PROJECT MEMO: 23 Ocean Avenue

RE: Response to Preliminary Staff Comments

Re: 23 Ocean Mixed Use

Response to Comments: 23 Ocean Avenue Development

**SECTION B-B' - RAIN GARDEN AND DRIVEWAY PERVIOUS PAVERS**  
NOT TO SCALE

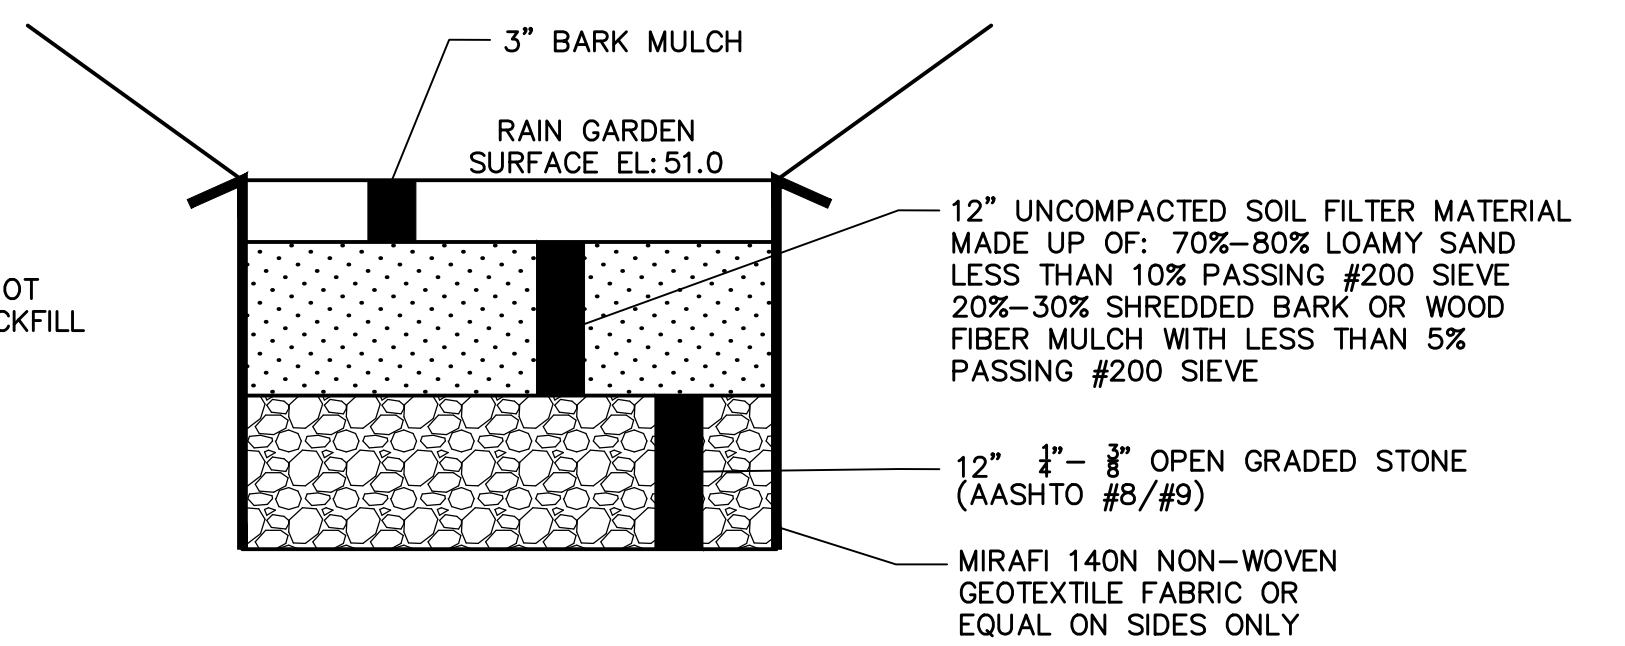
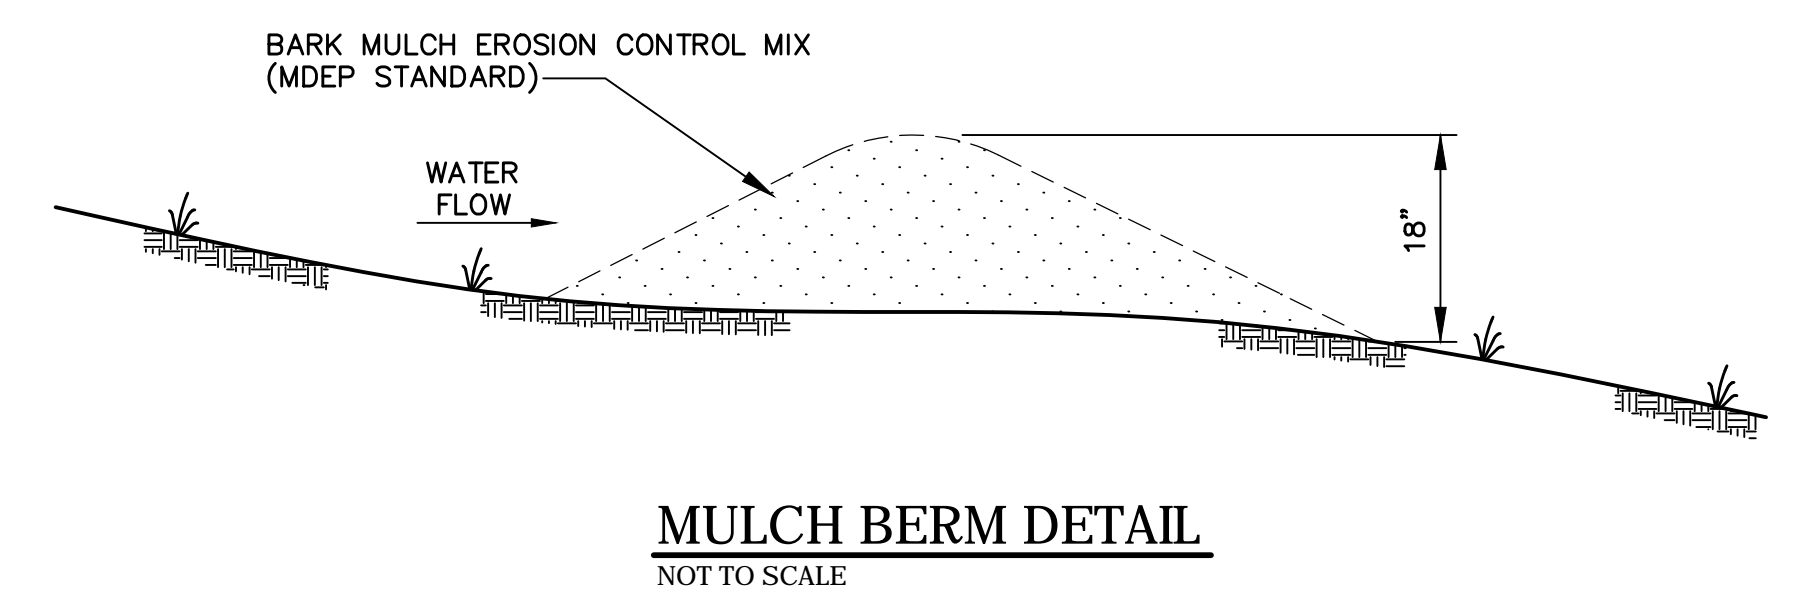
The proposed rain gardens do not appear to have any overflow structures or bypass outlets.

The rain garden in the southeastern corner of the site will overflow through the driveway apron to the Hersey Street gutter. This has been clarified on the plans and additional information on grading has been provided so that it is clear that overflows should through the driveway apron and not onto the sidewalk/esplanade.

**INLET PROTECTION - SILT SACK**  
NOT TO SCALE

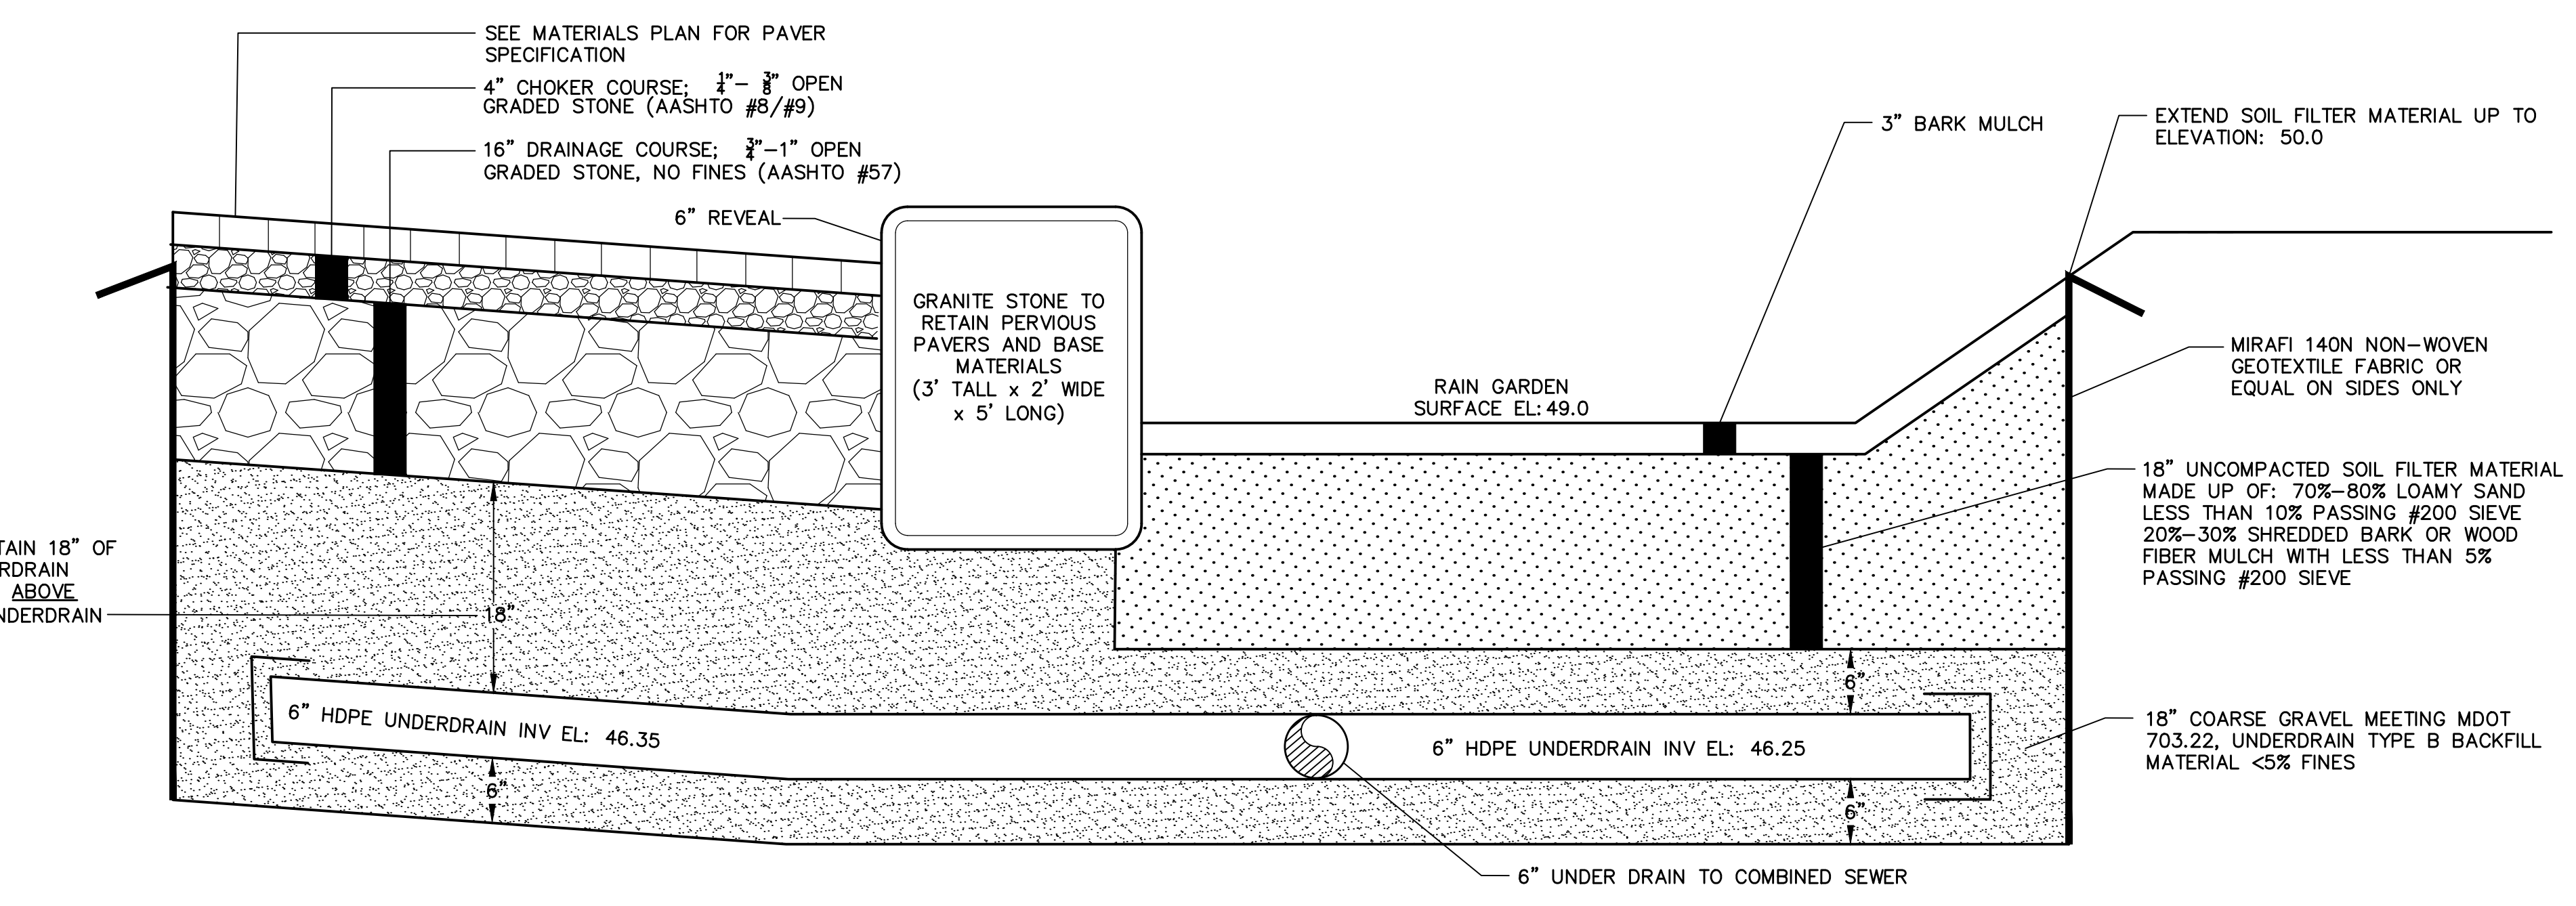
- a. Basic Standard: Plans, notes, and details should be provided to address erosion and sediment control requirements, inspection and maintenance requirements, and good housekeeping practices in accordance with Appendix A, B, & C of MaineDEP Chapter 500. The applicant has provided details, and notes indicating erosion control requirements, but we recommend the addition of erosion and sedimentation control locations on the plans and additional notes on inspection and maintenance requirements should be added to the plans to be in conformance with the standards.

Note 4 on sheet C-1 requires the contractor to inspect erosion control measures weekly and after rain events and to keep a log of the inspections. A mulch berm has been added along the eastern (down-gradient) edge of the property.

UNDERGROUND ELECTRIC/COMMUNICATIONS UTILITY TRENCH DETAIL
NOT TO SCALE

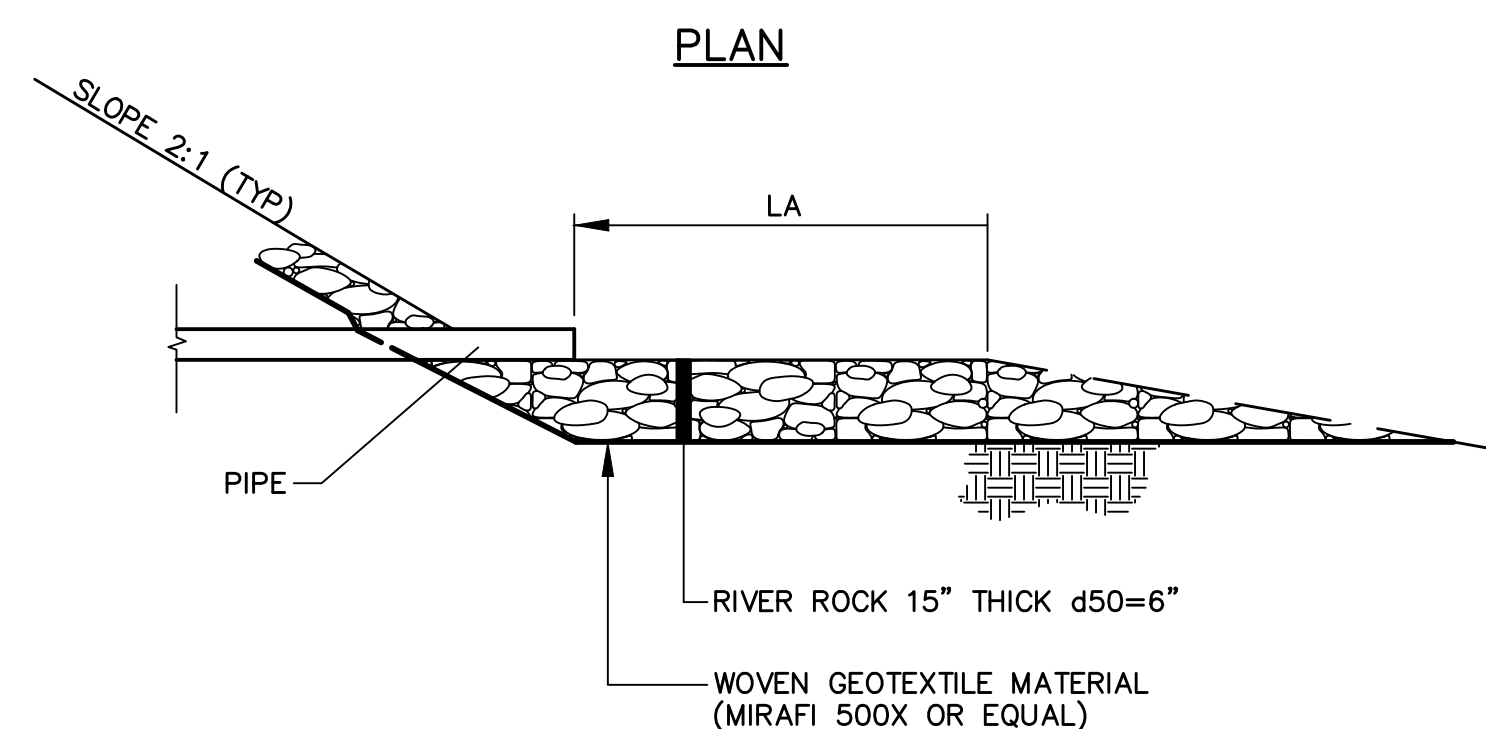
Comment #6. Overhead electric is not permitted. Please confirm a plan for underground electrical with CMP and revise plans accordingly. Can the existing pole on Hersey Street be removed?

3. The proposed underground gas and electric utilities will be located beneath an existing hedge located along Ocean Avenue. The site preparation plan notes that the hedge is to remain, and the landscaping plan does not provide any new plantings in this area. The Applicant should comment on the plan for maintaining this existing landscaping with the proposed utility installation.

Response: The utility plan has been revised to provide underground electrical service from Hersey Street. Owner will work with utilities to remove the existing pole adjacent to the new building if feasible. However; it may not be feasible to remove this pole because it appears to be a strain pole intended to offset the pull of the sizeable 3-phase service to the restaurant across Hersey Street. If it is not feasible to remove this pole, owner will work with utilities to install a sidewalk guy to support the pole while minimizing pedestrian impacts.

The proposed utilities have been reconfigured as described above and are no longer in conflict with the hedge. The hedge will remain.

REINFORCED CONCRETE SIDEWALK
NOT TO SCALE

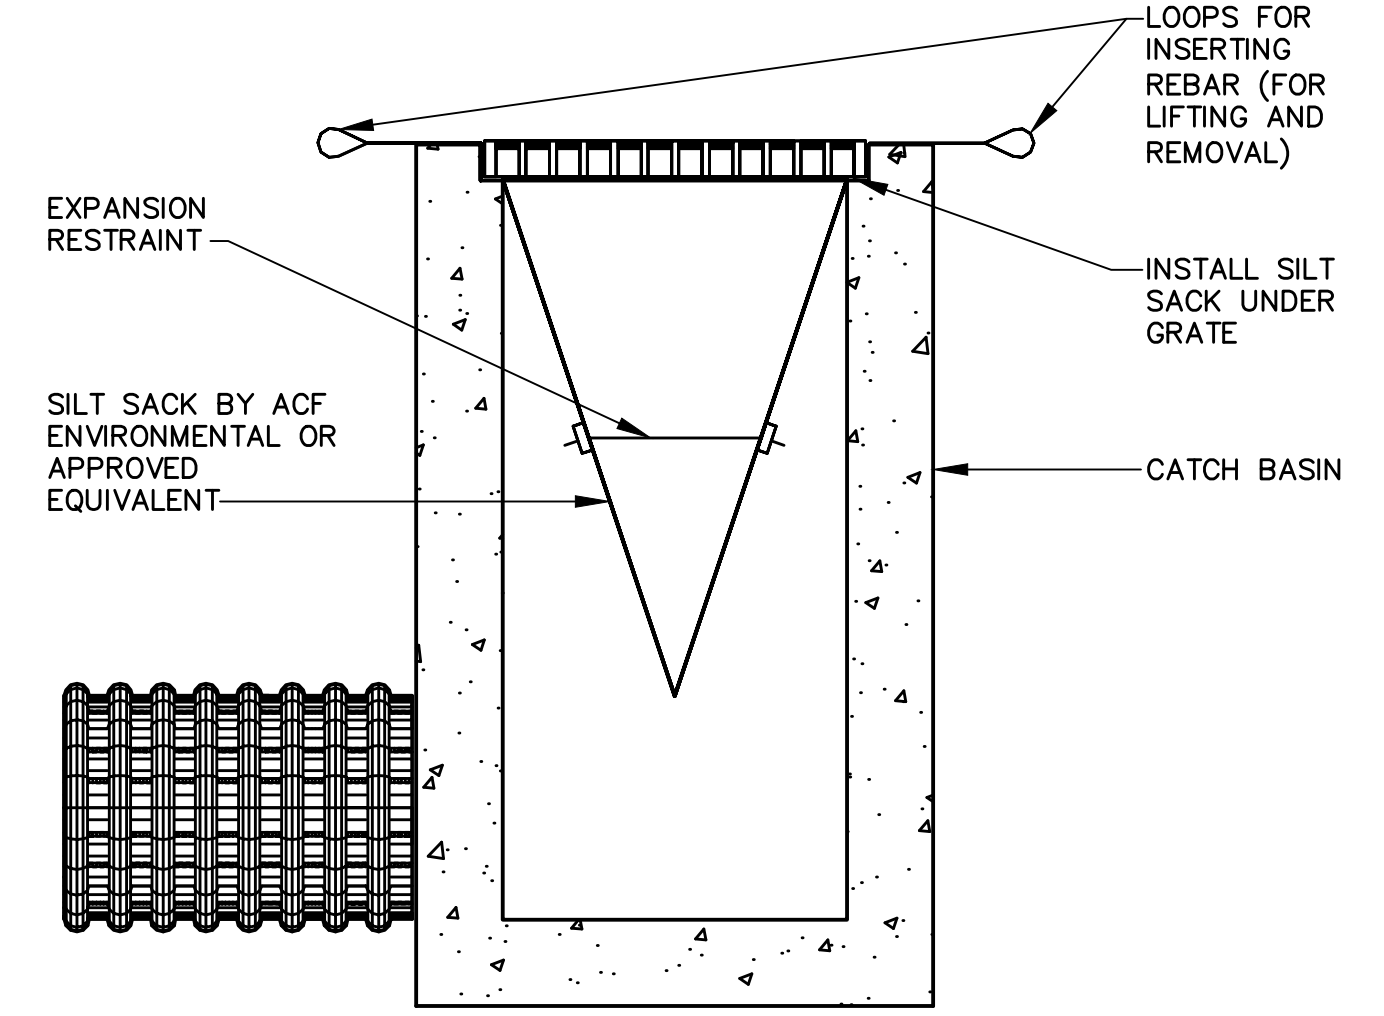
Comment #8. *The plans do not include full replacement of the sidewalk on Ocean Avenue along the entire property frontage. The applicant should either include full sidewalk replacement or document justification for the current proposal.*

Response: The site plan has been revised to indicate that the sidewalk will be replaced along the entire frontage on Ocean Avenue and Hersey Street.

9 WOOD GUARDRAIL
NOT TO SCALE

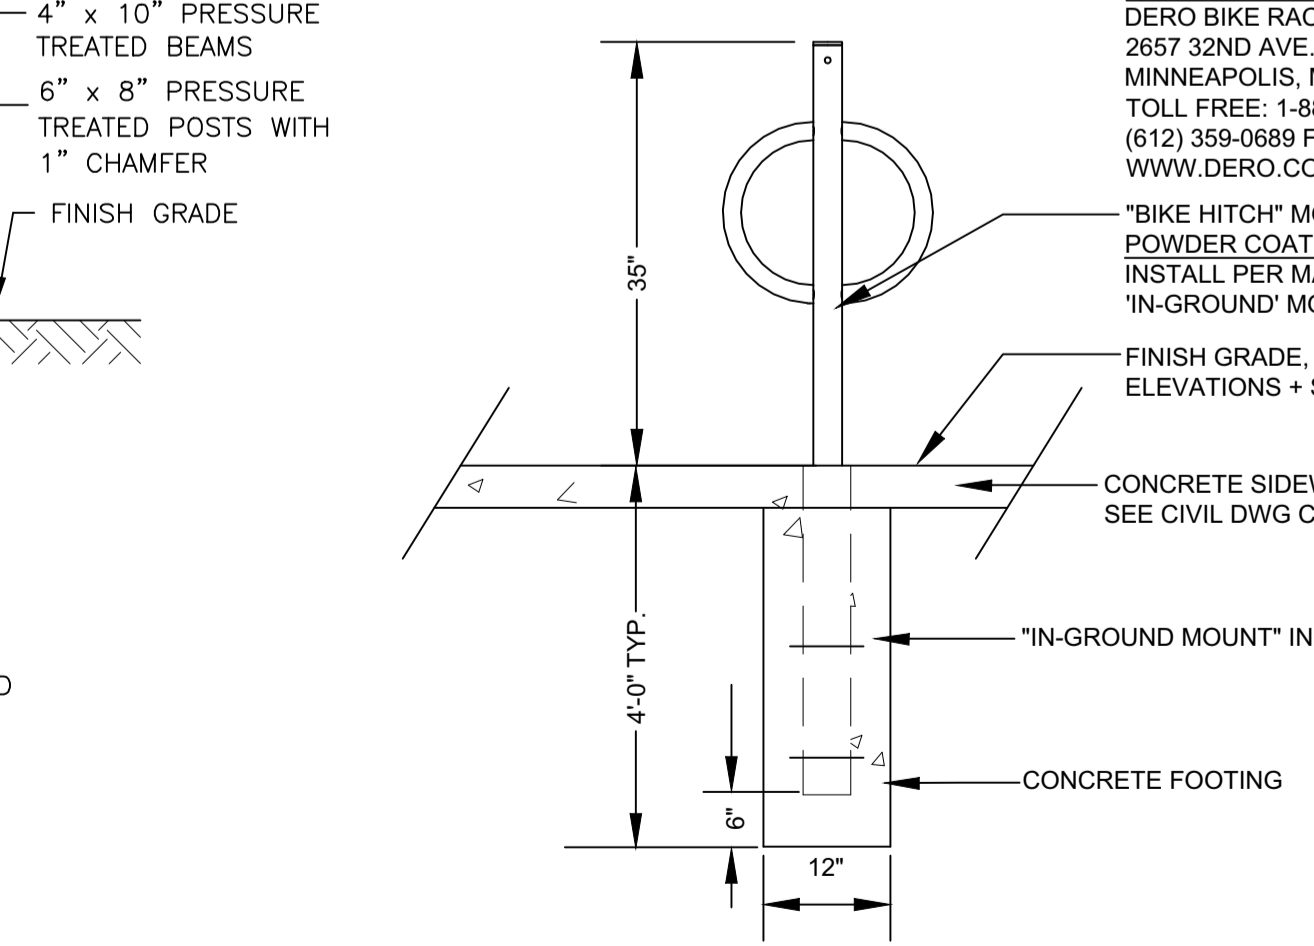
Comment #2. Thus we would like to see 'set-back' tree planting in available spaces. Also parking lot on Hersey Street should have a 4' buffer with plant material at back of sidewalk. A smaller 3' or 2' buffer might not make it. Ideally like to see woody shrub planting but could do ornamental grasses. Wood guardrail on the parking lot side is needed to protect this space from vehicles, snow etc. Without protection plant material would likely be damaged. This buffer on the residential side is more important than the more commercial Ocean Avenue side. Add a couple of trees on the parking lot edge to buffer parking lot from next door residential use. See photos, (I got creative with the pics.

Response: The landscape plan has been revised to accommodate a guardrail along the Hersey Street sidewalk and significant vegetated buffer associated with the adjacent rain garden. Additionally, the hedgerow has been extended along the east and north property lines to provide screening and privacy for the abutting residential neighbors.
